Sussex Wildlife Trust

These comments follow on from our previous submission (RR-381). Sussex Wildlife Trust's RR still stands. We note that Natural England have provided a submission (RR-265) which covers these areas of concern in significant detail to be carried forward in the examination process.

Below is a tabulated format of further commentary we are providing on specific aspects of the submission. This further submission is not exhaustive and an absence of comments should not be considered as support for the approach.

Figure 5 Example output from routeing study showing bream nest area and separation distance (extract from Global Maritime routeing study)

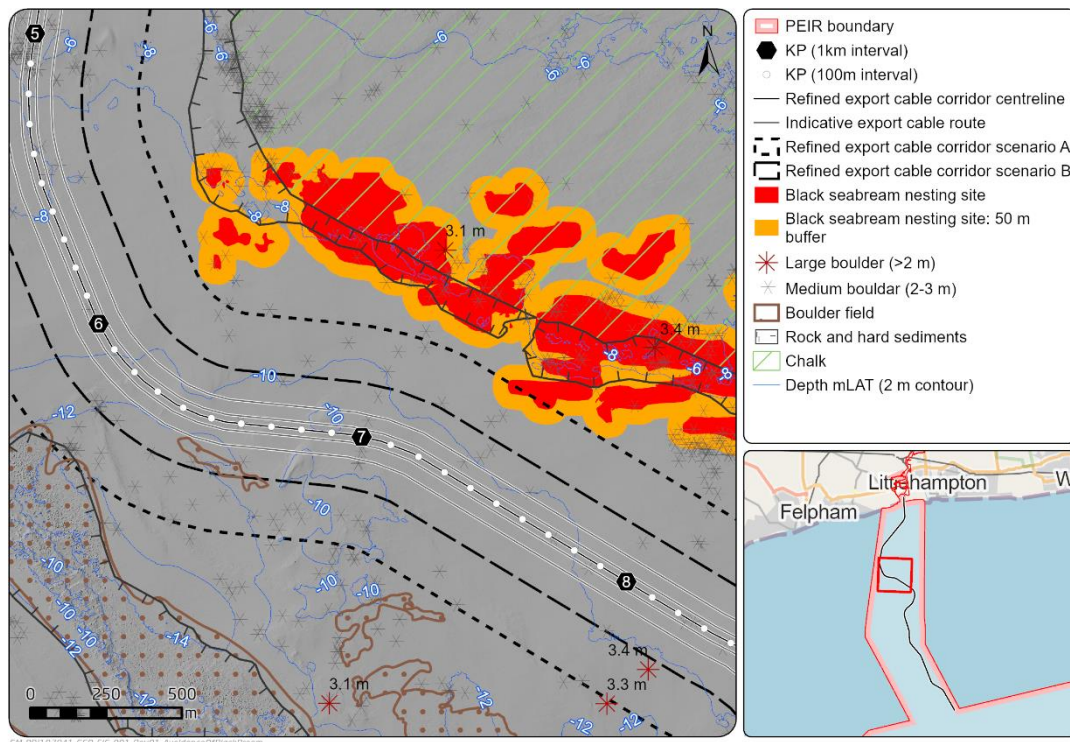
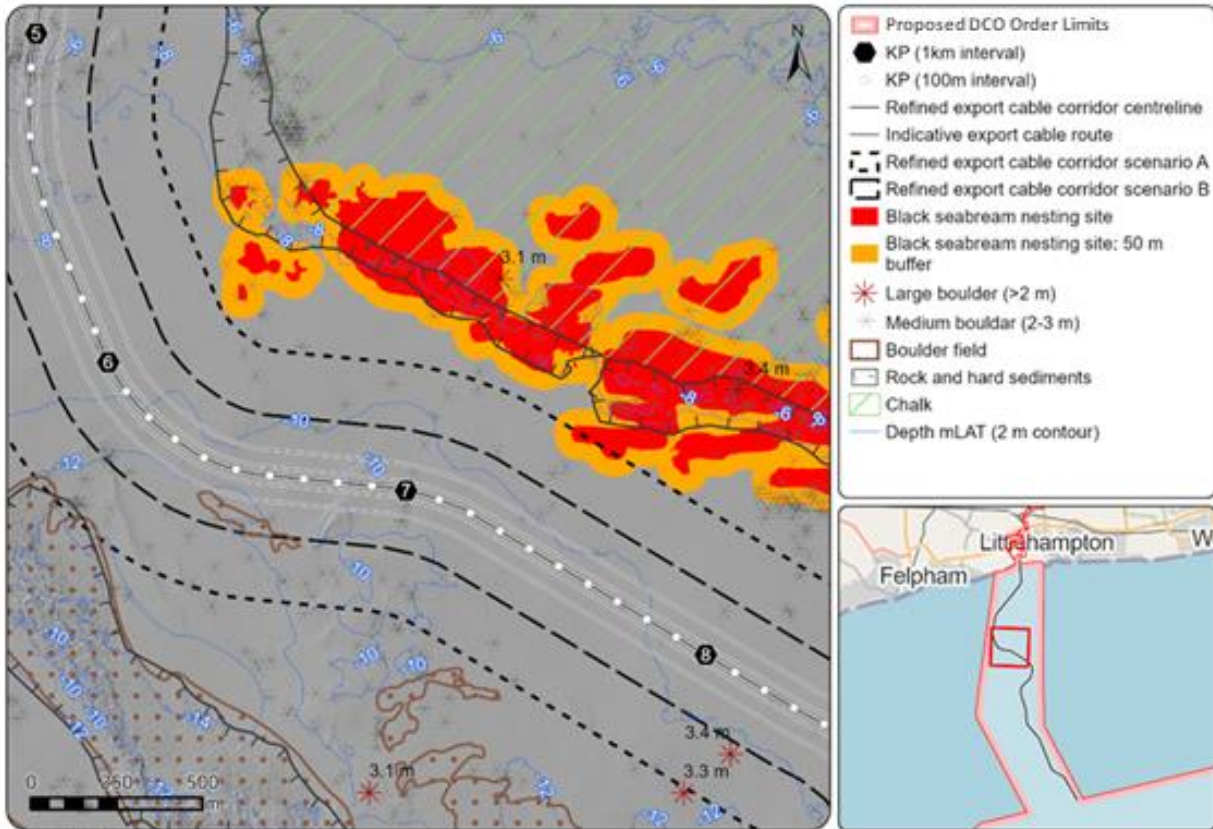
C-270	<i>As part of the routeing design, a working separation distance (buffer) will be maintained wherever possible from sensitive features, notably black seabream nesting areas, as informed by the outputs of the physical processes assessment, to limit the</i>	We suggest that the distance(s) should be specified here.
